Demolish 1 house (60 Sea Lane); partially demolish 1 house (45 The Ridings); construct 3 detached houses; alterations and extensions (45 The Ridings)
45 The Ridings and 60-62 Sea Lane East Preston

Thank you for your internet representation made on 26th April 2013 which has been recorded as '**an objection**' with the comments as follows:

FLOOR PLANS & ELEVATIONS
UNIT 3

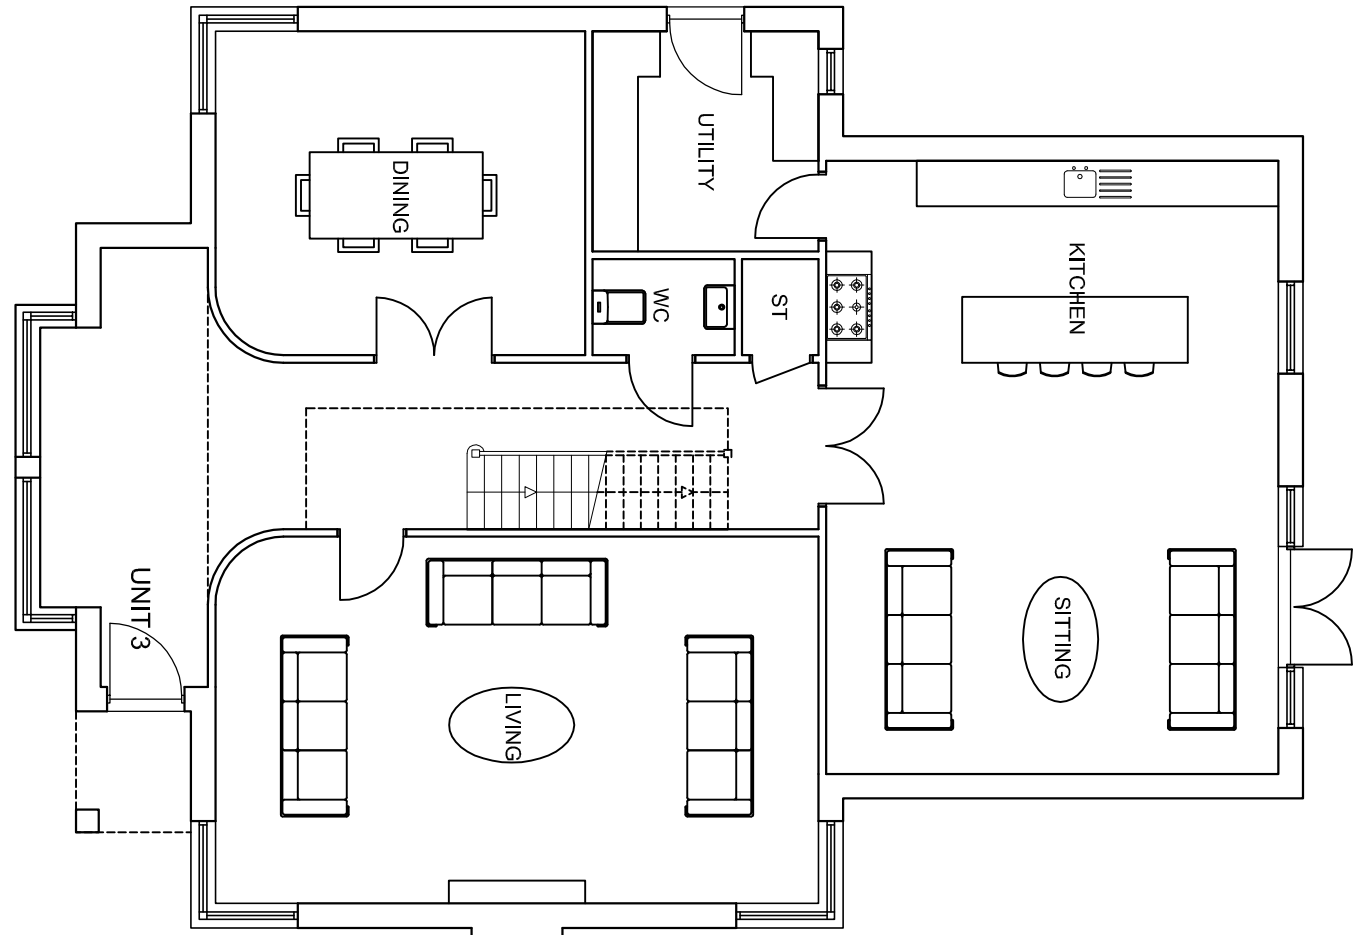
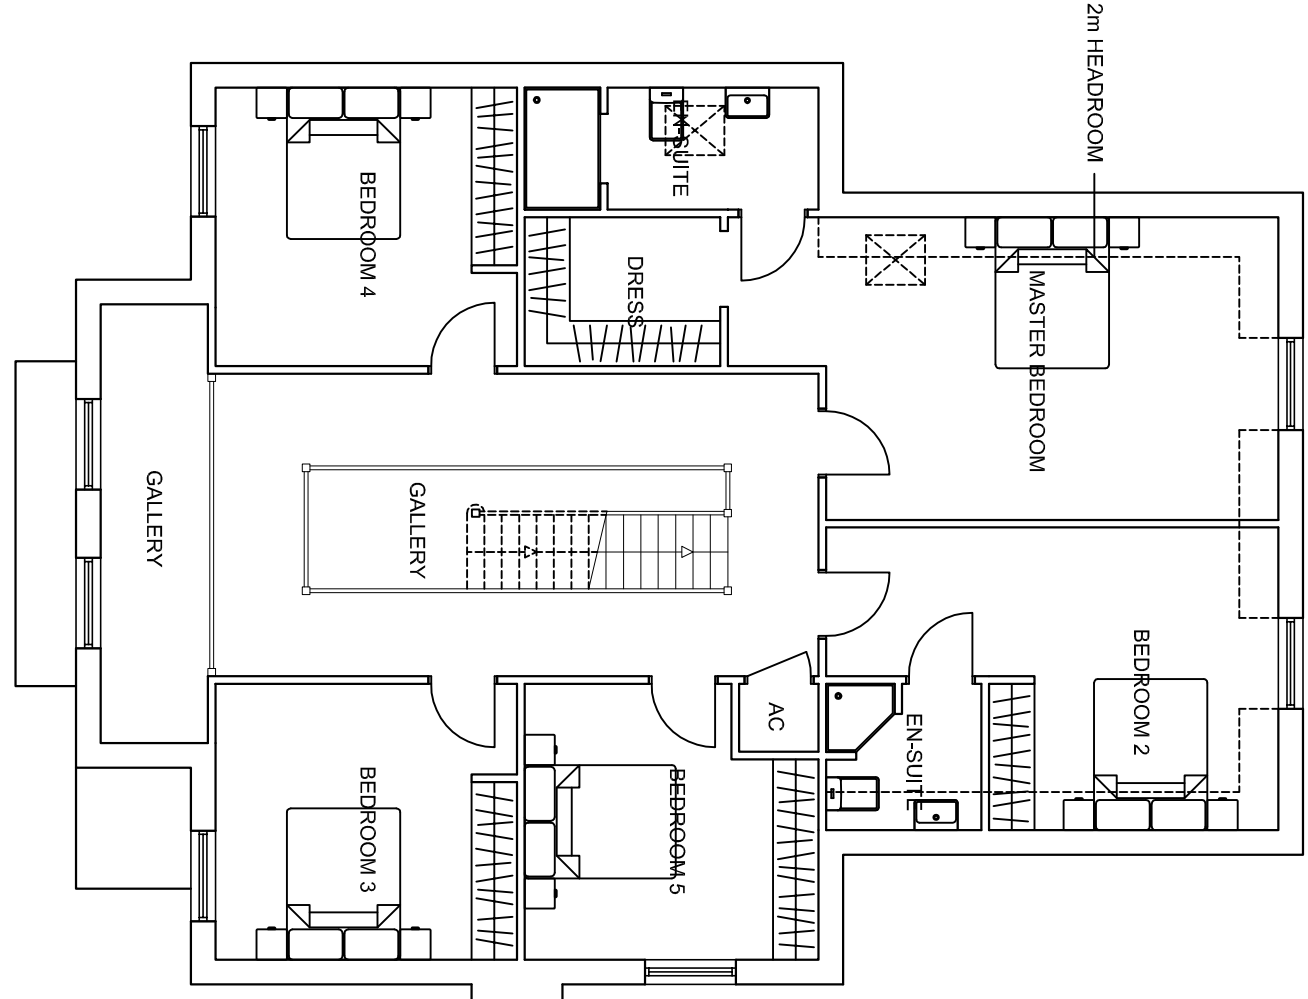
The proposed dwelling at 62 Sea Lane has a bedroom window in the south elevation which will look directly into our existing bathroom. The number of bedrooms being 5 (which is not in keeping with properties either side) could be reduced to 4 and avoid the necessity for this window. Thank you
